Sent: 15 July 2010 14:28
To: Planning
Subject: Comments Added: 30 Astrick Avenue, Hatfield

Application ID: S6/20101/1371/FP Mr M Peacock Application Owner: Welwyn & Hatfield Borough Council (Development Control Officer)

Location: 30 Astrick Avenue, Hatfield

Description: Partial demolition of existing single storey rear extension and covered area, replacement of demolished building with new pitched roof single storey rear extension. Raising hipped main roof to gable a

FRONT ELEVATION. (proposed)

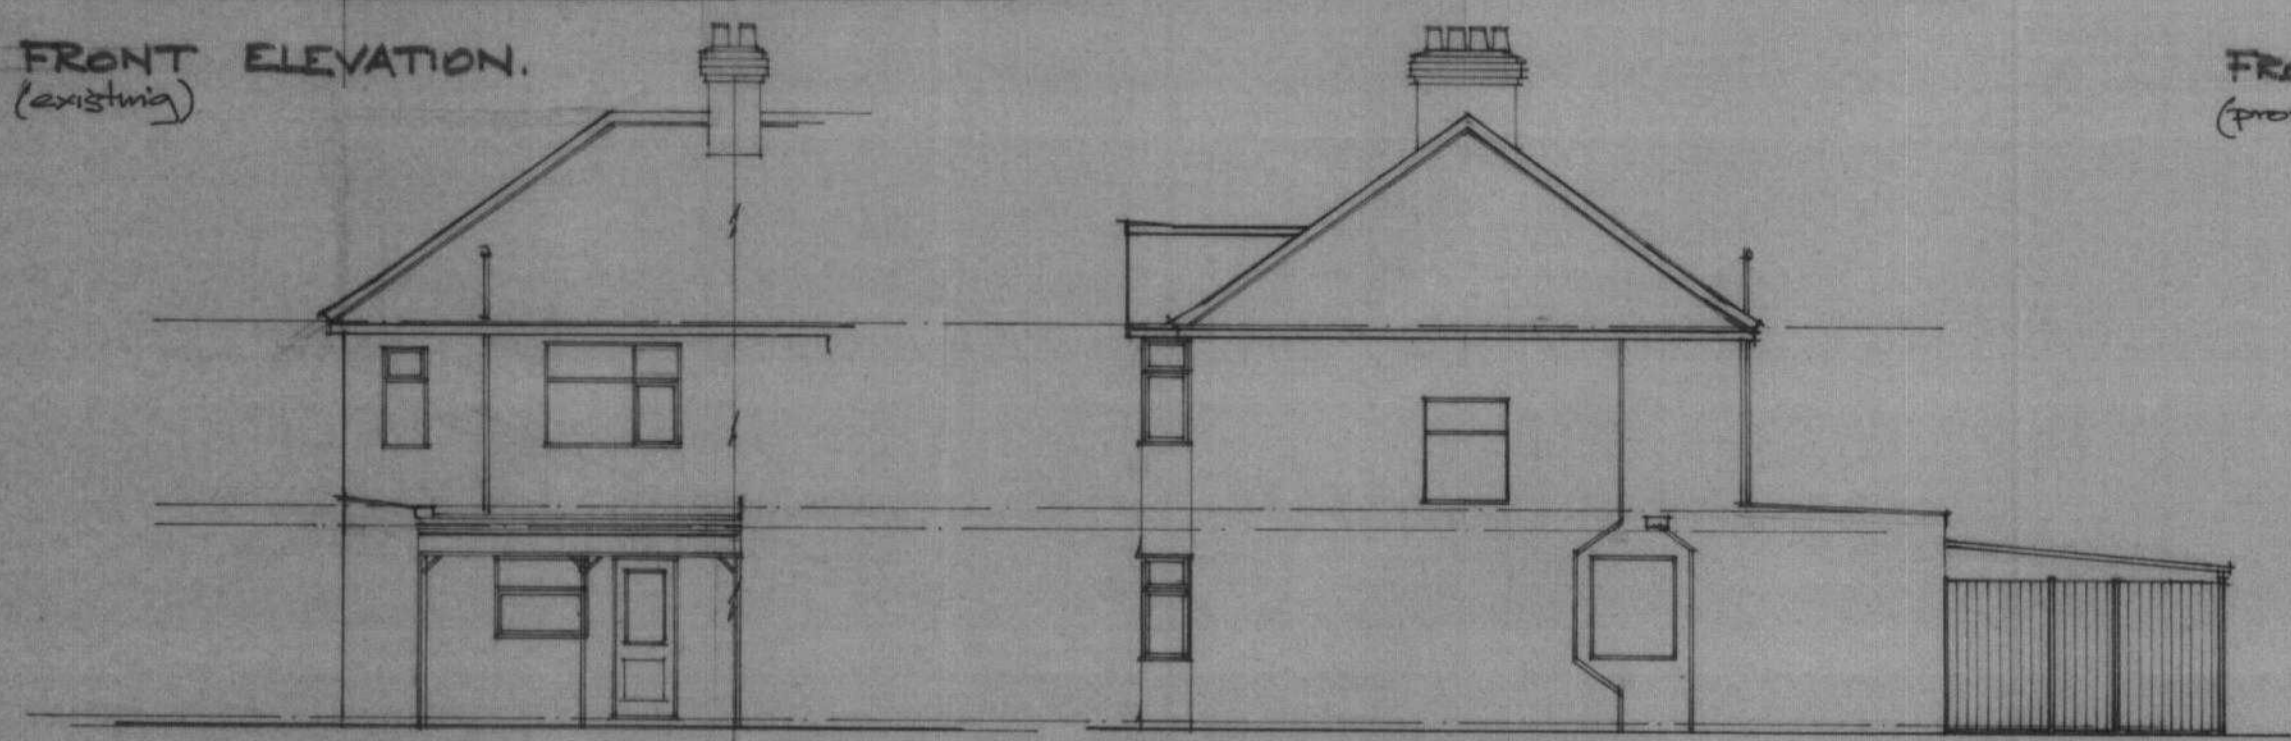
Comment: The Town Council have just the one objection to this application. The rooflight on the second floor at the front of the property. The Council consider the rooflight out of keeping with neighbouring properties and therefore inappropriate.
